Hornsea Project Four

Applicant's comments on other submissions
received at Deadline 3

Deadline 4, Date: 10 May 2022
Document Reference: G4.10
Revision: 01

Figure 1: The different sides of the LEB, showing the two "eye" size differences and the height above sea level achieved through the use of dahn buoys (images courtesy of a participating fisher).

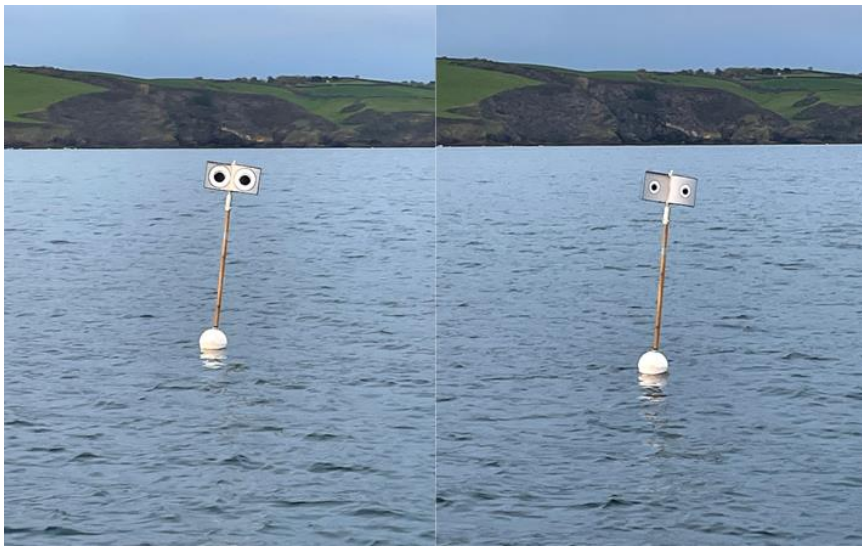
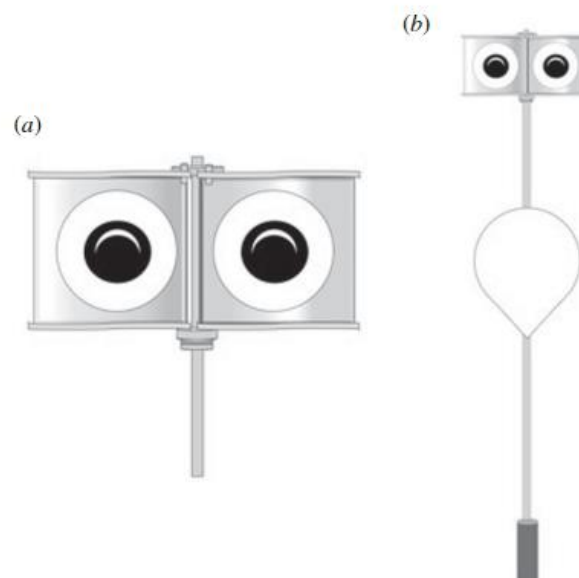
<p>C26 (RR-029 Appendix C Summary table: target fishery)</p>	<p>Natural England are concerned that the Applicant is not clearly committing to a second year of trials for the LEB (REP1-021). We consider that the LEB remains unproven in a fishery setting or for the species of concern, and its effectiveness must be proven through a robust trial. A single year (in fact, only a winter 'season') of data collection is not sufficient as interannual variation cannot be considered. Further, the raw data must be available in order for us to fully review such a trial, and we understand that only proportional reductions in bycatch will be reported. We appreciate this is a request of the fishery and recognise the sensitivity of the data in question, but therefore must highlight the lack of co-operation and transparency that this suggests, as well as the inherent risk to the perceived legitimacy of the trial results.</p>	<p>The Applicant is confident that the Looming Eye Buoy (LEB) is a viable compensation measure and the preliminary results of the bycatch reduction technology phase using the LEB are promising, with similar bycatch reduction as identified in Rouxel <i>et al.</i>, (2021). We are therefore confident in the LEB technology and therefore do not consider a trial will be necessary. The Applicant will provide an update on the bycatch reduction technology selection phase at Deadline 5 once the full analysis has been completed.</p> <p>We acknowledge the stakeholder comments regarding a second year of data collection. Hornsea Four plan to implement the LEB on vessels between the last quarter of 2022 and the first quarter of 2023 as part of implementation, to reduce risks in terms of stakeholder relations, to inform strategic compensation and to maintain relationships with fishers to prepare for delivering the compensation measure should it be required.</p> <p>As previously stated in G1.9 Applicant's comments on Relevant Representations (REP1-038), due to contractual restrictions, the results of the bycatch reduction technology selection phase can only be disclosed as percentage reductions in bycatch, i.e. not specific numbers of birds, without consent from the participating fishers. It is vital that the Applicant maintains the excellent relationship with fishers to ensure the long-term implementation of</p>

Figure 2: Examples of guillemot nesting sites within the Bailiwick of Guernsey. Top panel shows the islets of Fourquie and La Nache. Bottom panel shows guillemot on cliff habitat on La Nache.

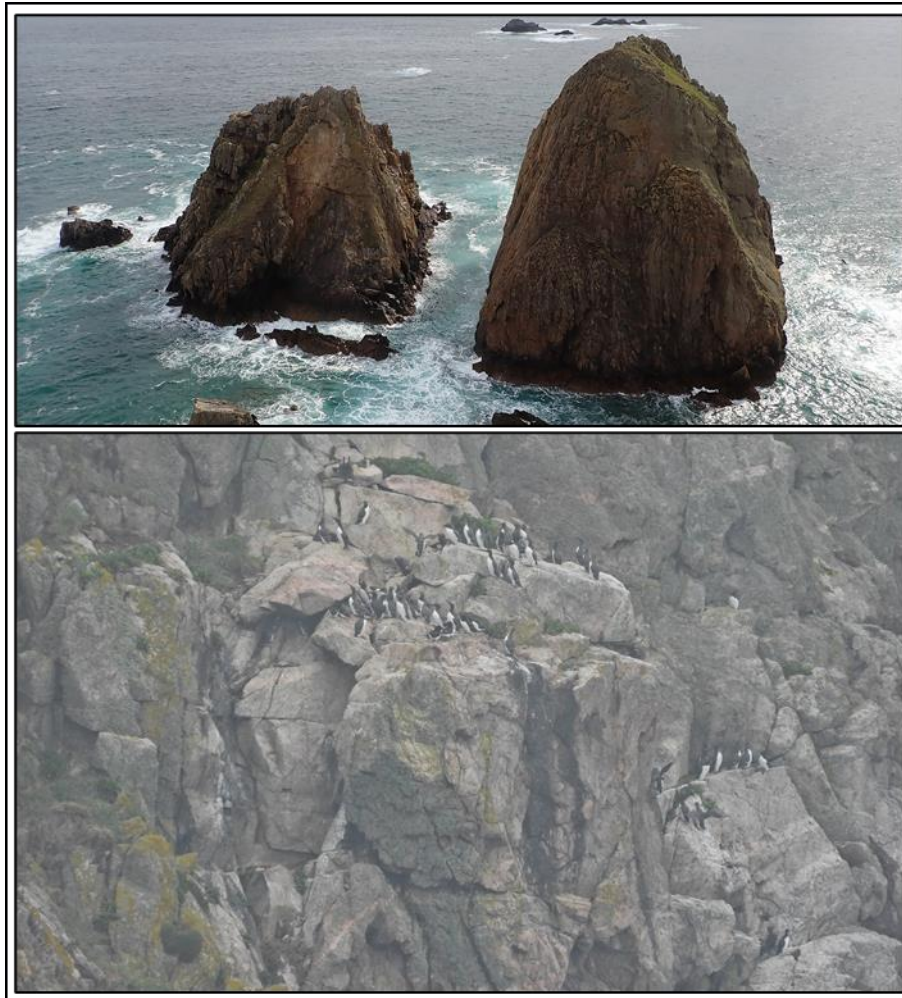
C24 (RR-029 Appendix C 92)	<p>Natural England have reviewed REP1-061 (G1.33 Predator eradication island suitability assessment: Bailiwick of Guernsey Revision: 1.1). As acknowledged in that document, any assessment of potential nest sites and breeding population potential at a site following predator eradication will be subject to numerous limitations and assumptions. Any colonisation potential, or increase of an existing population or its productivity remains highly speculative. We suggest that it may prove useful to</p>	<p>The Applicant has based the calculations within their REP1-061 on precautionary breeding densities for guillemot when compared to other published densities for the species. The Applicant remains cognisant of potential opportunities to ground truth the island suitability assessment and will provide an update to the report following results of the eradication implementation study. The</p>

Reference	Stakeholder's Written Representation	Applicant's Response
	<p>ground truth the nest site identification process detailed in REP1-061 to give a greater level of confidence in its utility. This could be readily achieved by applying it to discrete areas within existing colonies (photographed occupied, and unoccupied, preferably in winter with minimal guano staining). We maintain that due to outstanding uncertainties with the measure and baseline data, the amount of compensation deliverable is not currently possible to quantify. This will be reviewed at Deadline 5 when the results of the feasibility study are submitted (RR-029-APDX:C-92).</p>	<p>Applicant clarified during Issue Specific Hearing 5 that the analysis of MRSea v2 in comparison to MRSea v1 demonstrates that MRSea v1 was suitable for use for assessment purposes and was sufficiently precautionary. Therefore, the impact assessment and compensation as submitted at DCO application is robust and sufficient.</p>
